Subject: Hydrant condition - BN/151/20/PL Land at rear of Poachers Eastergate Lane Eastergate PO20 3SJ

HYDRANT CONDITION CONSULTATION WITH PLANNING AUTHORITY

Planning Ref: BN/151/20/PL

Description: Erection of 1 No. 4 bedroom detached dwelling with detached carport (resubmission following BN/46/20/PL). This site is in CIL Zone 3 & is CIL Liable as new dwelling & is a Departure from the Development Plan.

PROPOSED SITE PLAN

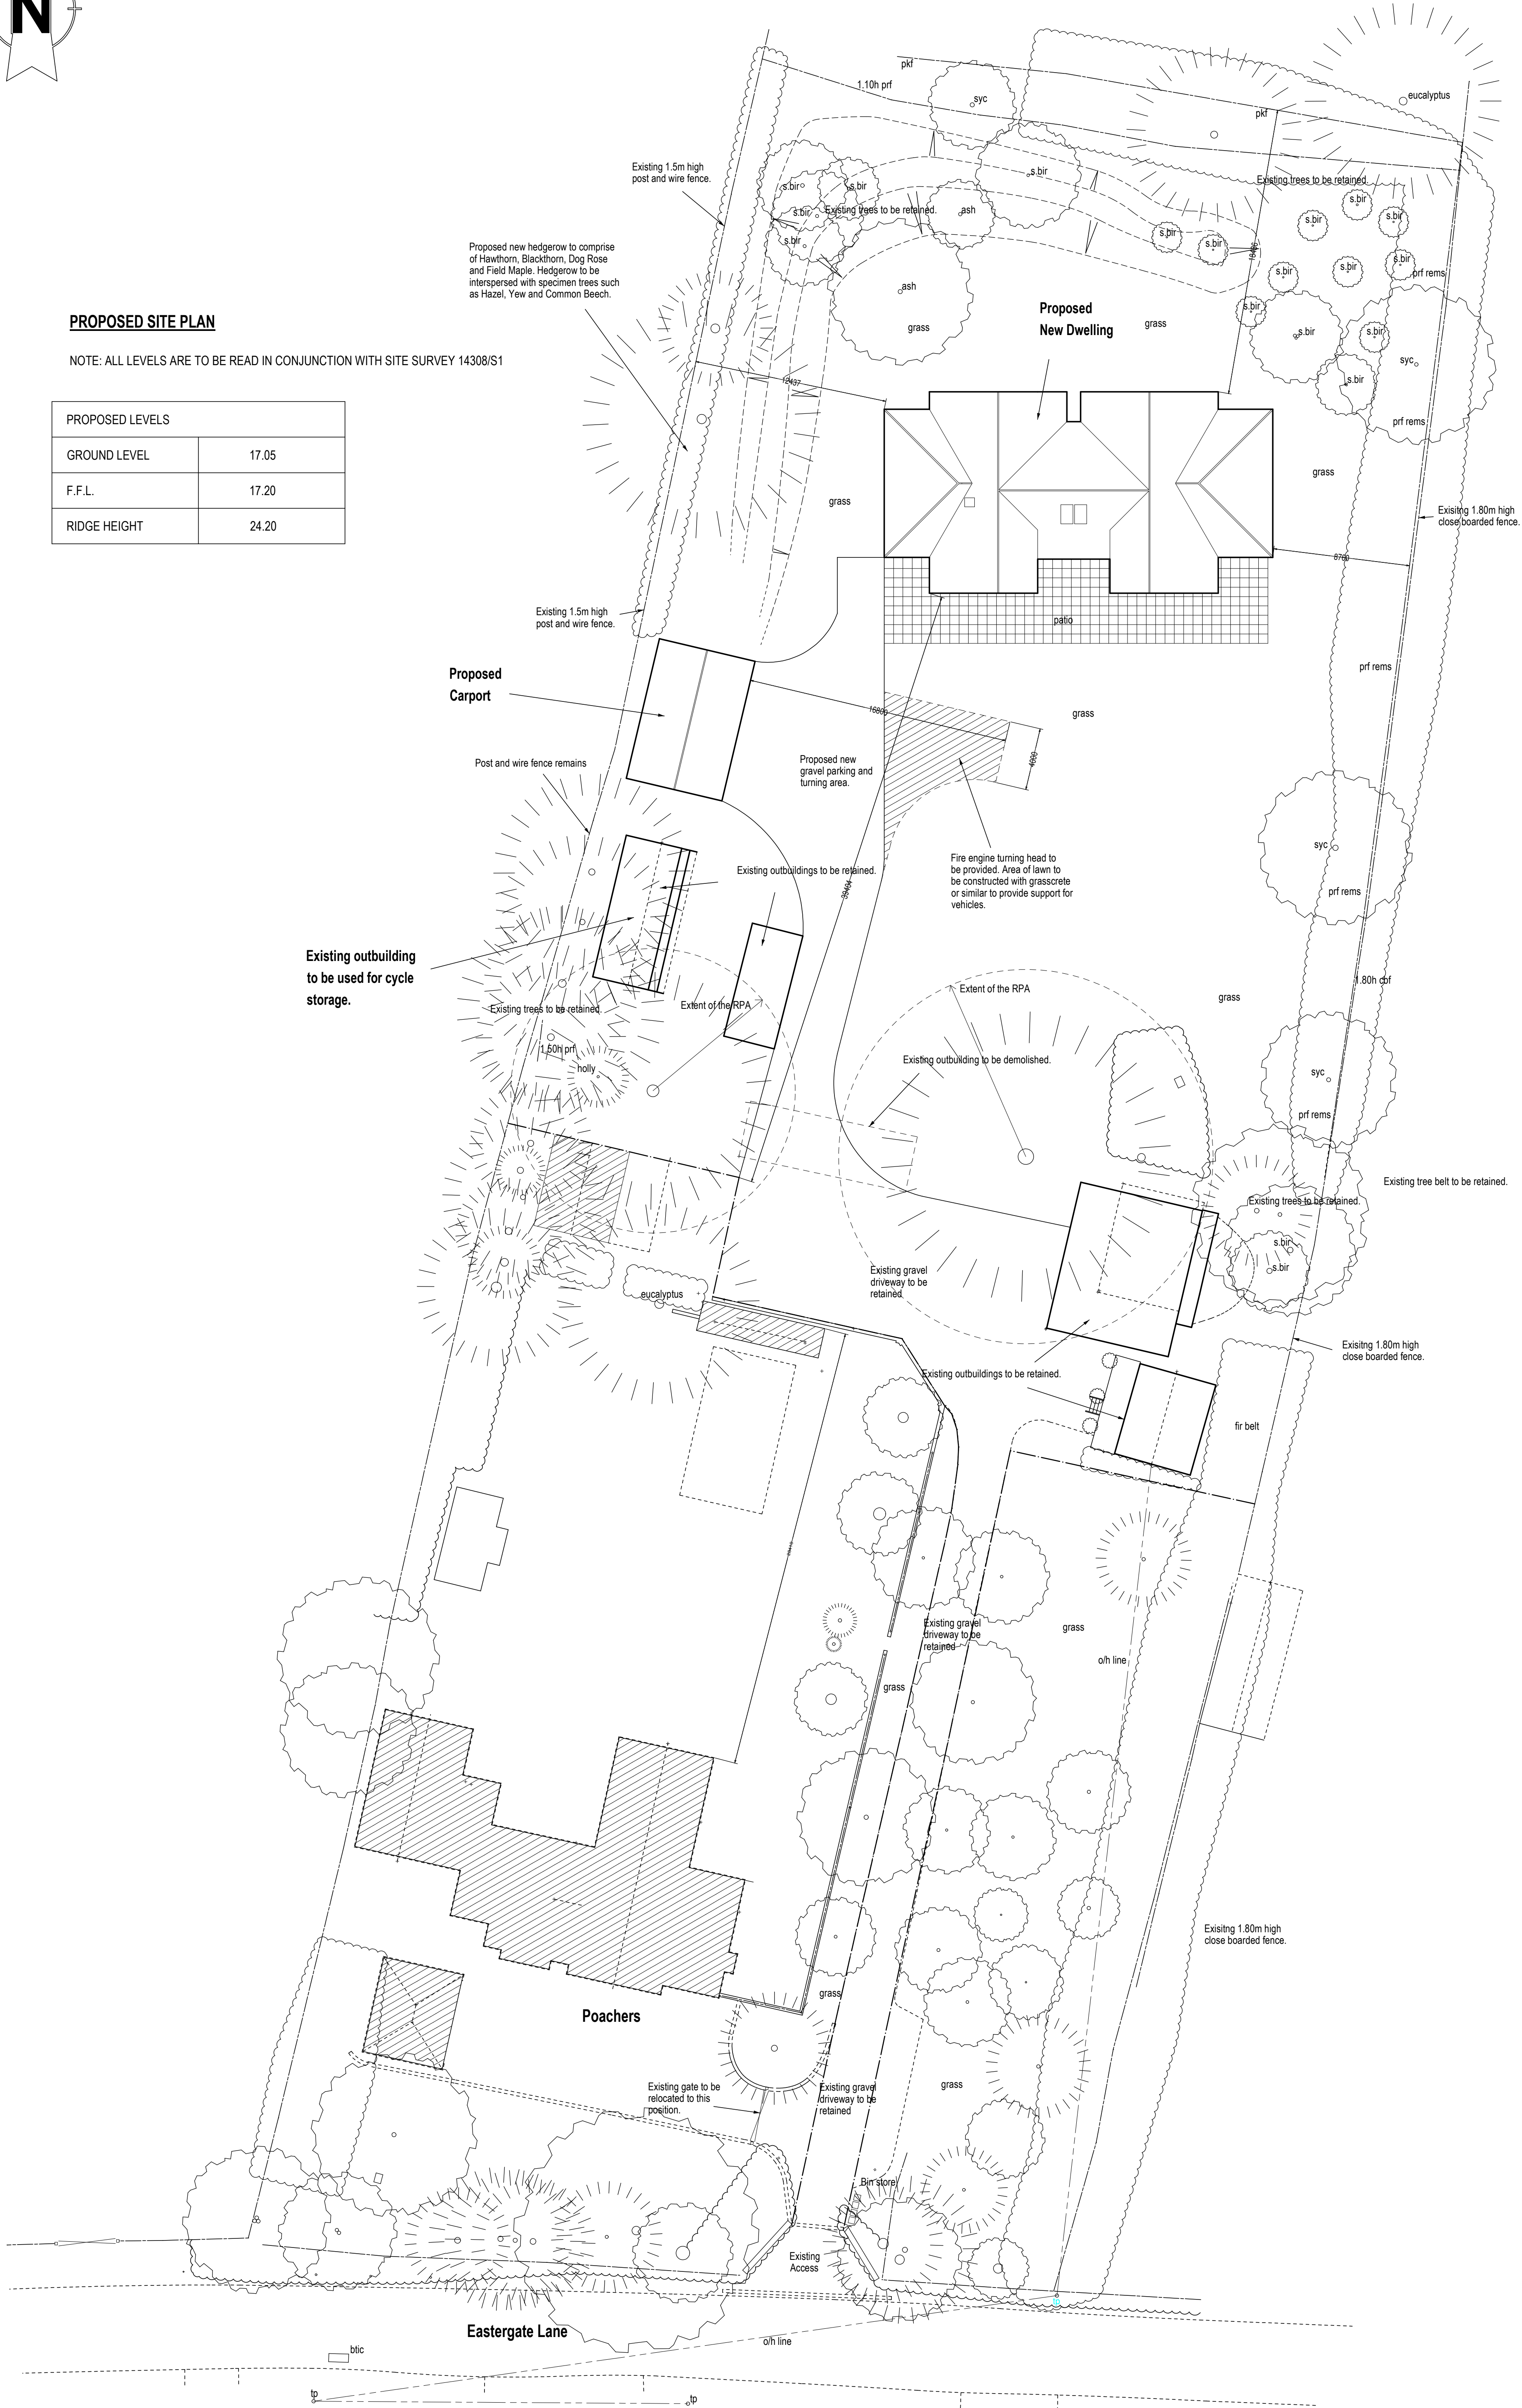
Please find attached a planning condition for application no. BN/151/20/PL for the requirement of an additional fire hydrant. Currently the nearest Hydrant to these proposed properties is 260 metres away. The supply of water for firefighting for a domestic premises should be within 175 metres.

Evidence will also be required that Fire Service vehicle access meets with the requirements identified in Approved Document B Volume 1 2019 Edition: B5 Section 13, including Table 13.1 and diagram 13.1.

- 1) Prior to the commencement of the development details showing the proposed location of [1] one fire hydrant or stored water supply (in accordance with the West Sussex Fire and Rescue Guidance Notes) shall be submitted to and approved in writing by the Local Planning Authority in consultation with West Sussex County Council's Fire and Rescue Service. These approvals shall not be unreasonably withheld or delayed.
- 2) Prior to the first occupation of any dwelling/unit forming part of the proposed development that they will at their own expense install the fire hydrant (or in a phased programme if a large development) in the approved location to BS 750 standards or stored water supply and arrange for their connection to a water supply which is appropriate in terms of both pressure and volume for the purposes of firefighting.
